Re: ACP Case reference: PAX92.324370 Littleton Wind Farm

Re: ESB's response to An Coimisiún Pleanála's invite to submit observations on the Strategic Infrastructure Development (SID) Planning Application for the development of a Wind Farm comprising of 11 no. turbines (and all associated works) in the townlands of Longfordpass North, Longfordpass South, Leigh, Bawnreagh, Clonoura, Noard, Derryhogan, Derryvella, Ballybeg, Lanespark, Newhill and Killeen in County Tipperary.

ACP Case reference: PAX92.324370

Applicant: Littleton Wind Farm DAC

<b>TITLE:</b>	Site Layout		
<b>PROJECT:</b>	Littleton Wind Farm		
<b>FIGURE NO:</b>	4.2.a		
<b>CLIENT:</b>	Littleton Wind Farm DAC		
<b>SCALE:</b>	1:20,000	<b>REVISION:</b>	0
<b>DATE:</b>	30/03/2026	<b>PAGE SIZE:</b>	A3

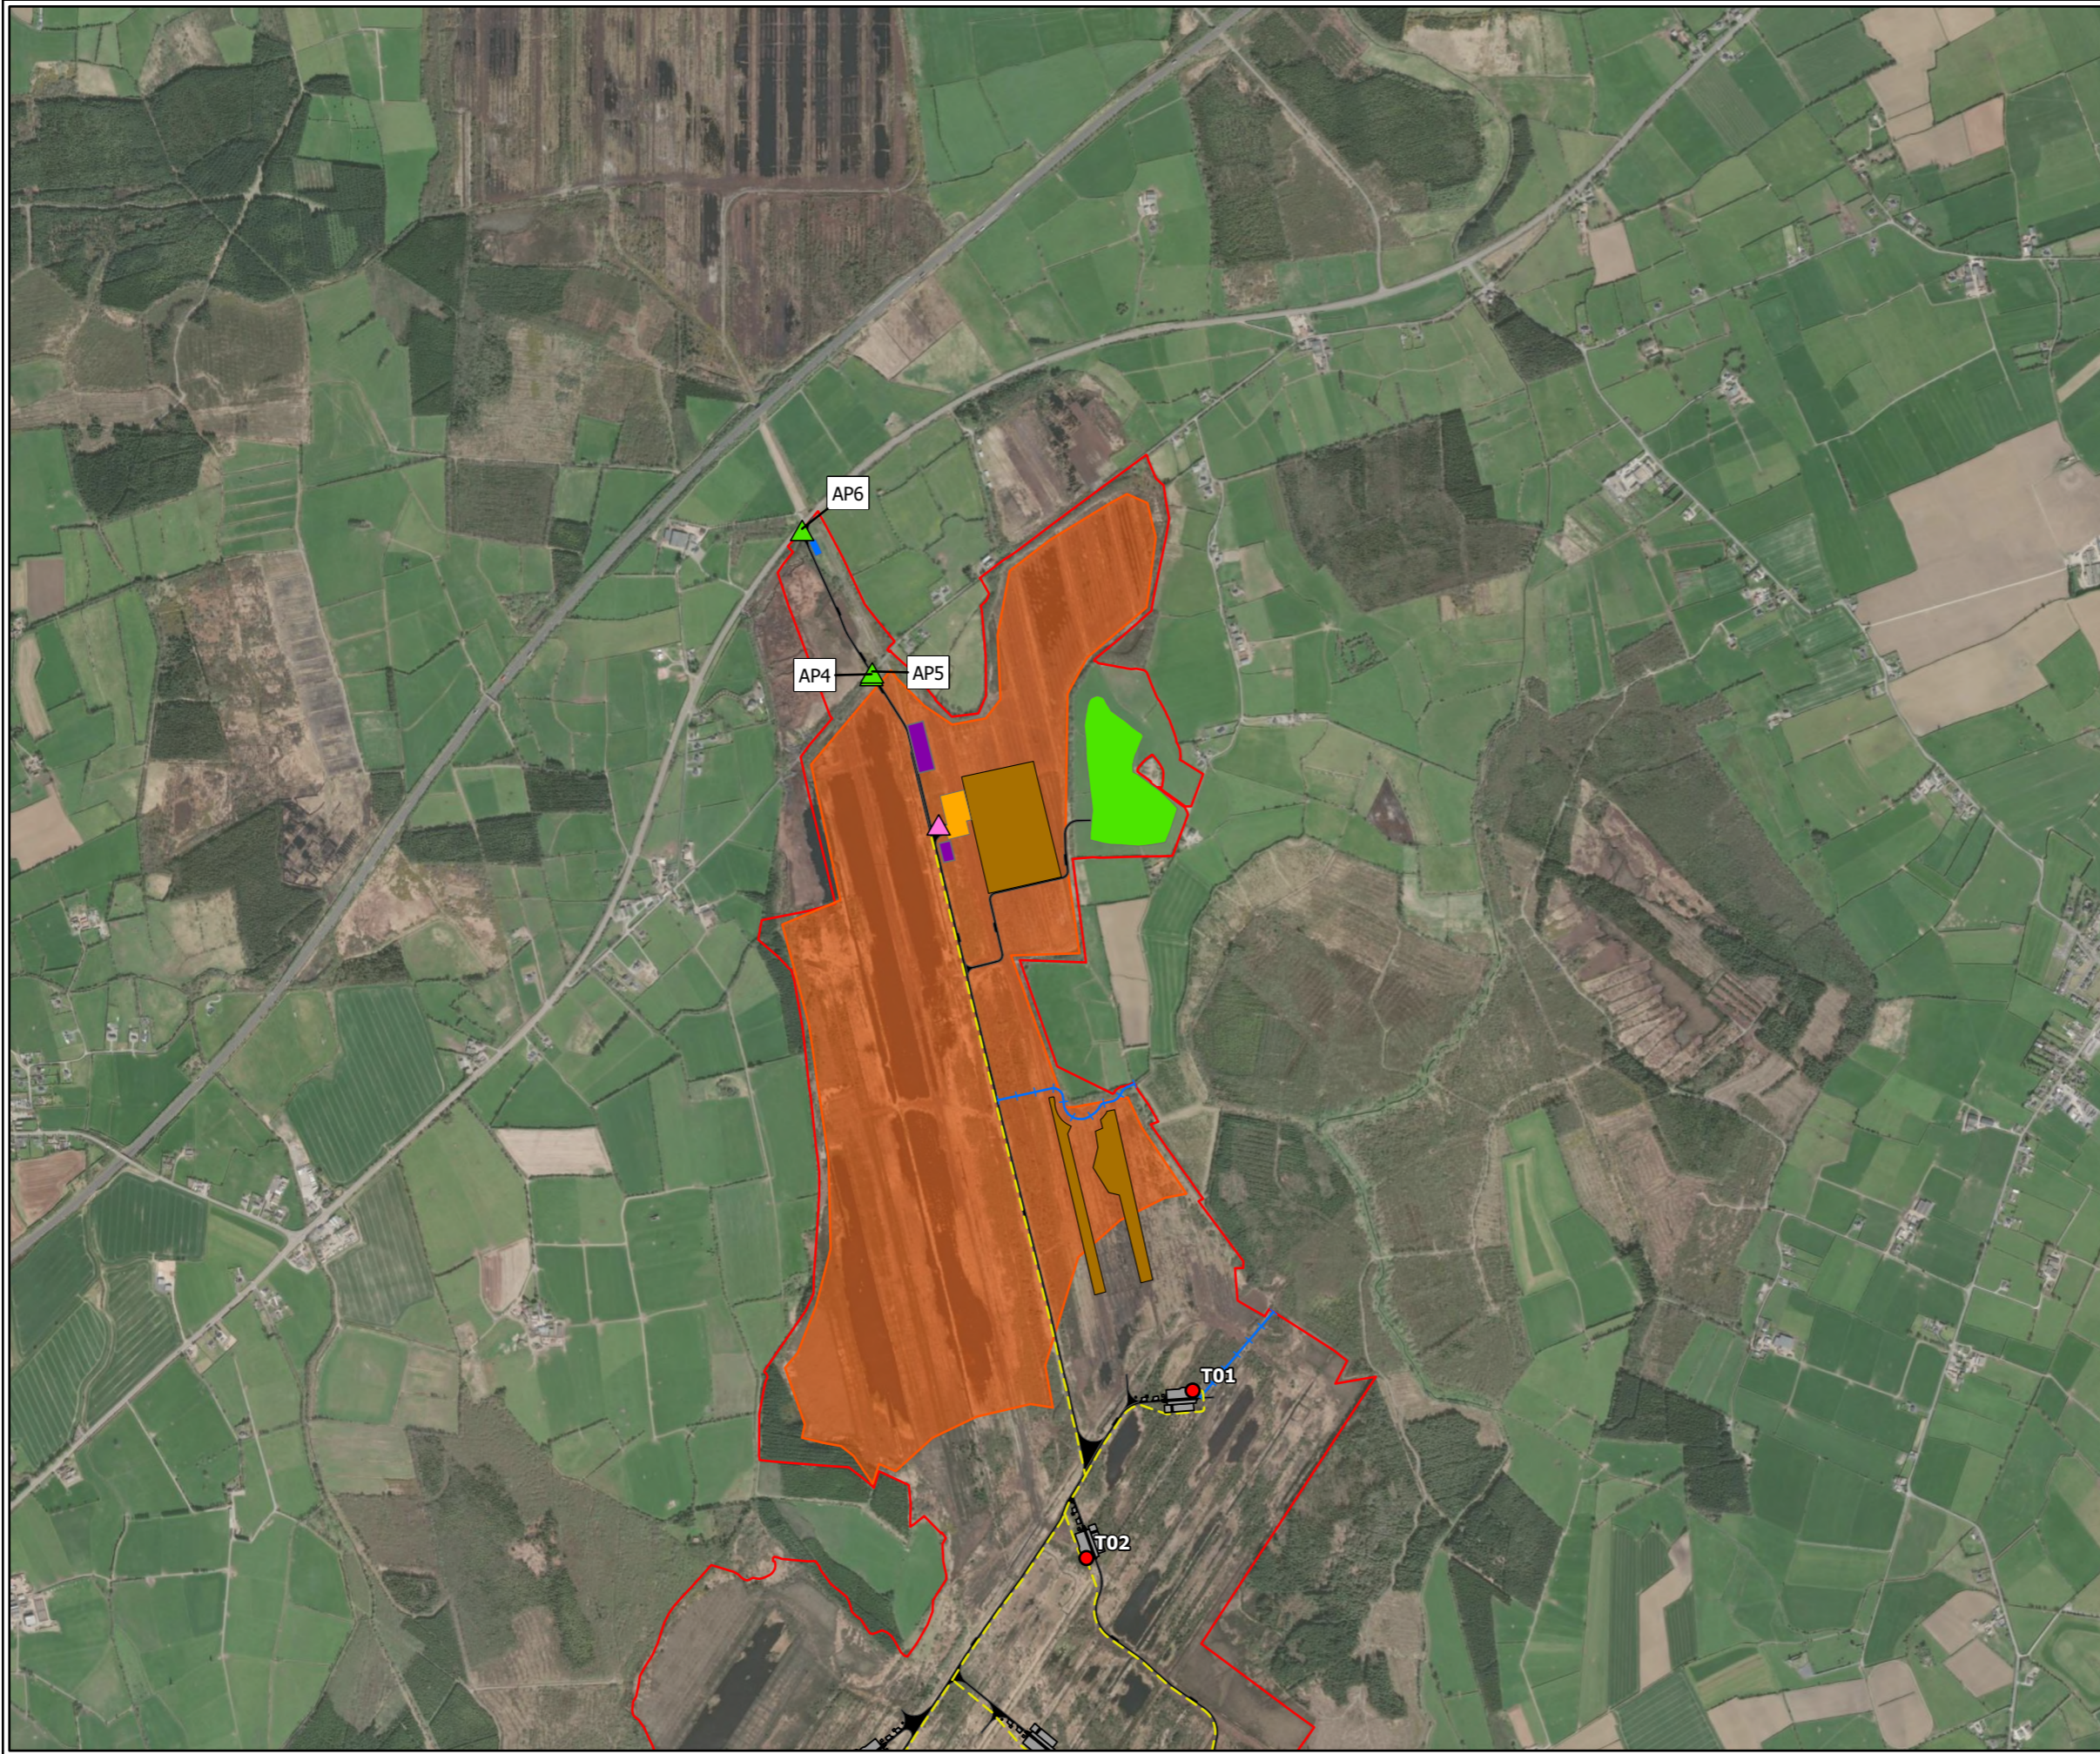
ESB supports the continued development of renewable energy infrastructure and recognises the important contribution that the proposed development can make towards Ireland's renewable energy and climate objectives. However, following a technical assessment of the application, ESB has identified a significant concern regarding the proposed location of **Turbine 4**.

ESB respectfully requests that the position of **Turbine 4** be reconsidered or relocated to an alternative position within the site.

ESB Networks Telecoms has identified potential interference arising within our critical radio communications network due to the proposed development of Littleton Wind Farm, Co. Tipperary. A detailed analysis of the development on our behalf by Joint Radio Company has identified that **Turbine 4** would cause interference to one of our SCADA Polling Radio (SPR) links, which is critical for the operation of ESB Networks. Furthermore, a review by the SPR design team has concluded that there are currently no satisfactory internal mitigation solutions available.

- **Turbine 4** fails the telecoms interference assessment.
- The turbine is predicted to impact **SPR link JESBCE00 - JESBCE07**.
- The expected concern would be diffraction interference, due to the intrusion of the turbine into the Fresnel Clearance Zone of the radio path.
- JRC notes that reducing the turbine micro siting allowance would not resolve the issue because the turbine location itself obstructs the link in the current proposed coordinates.

As there are no mitigation solution identified to protect this radio link it is strongly recommended that the position of **Turbine 4** be reconsidered or relocated. Should the developer wish to relocate the turbine, JRC (on behalf of ESN) can provide an exclusion zone report identifying locations that would avoid interference with ESB Radio Links.

In light of the above, ESB respectfully requests that An Coimisiún Pleanála require the relocation of **Turbine 4** to a position that does not interfere with the SPR radio network. This is a targeted and proportionate measure that would address the identified telecommunications constraint while allowing the remainder of the proposed wind farm development to proceed.
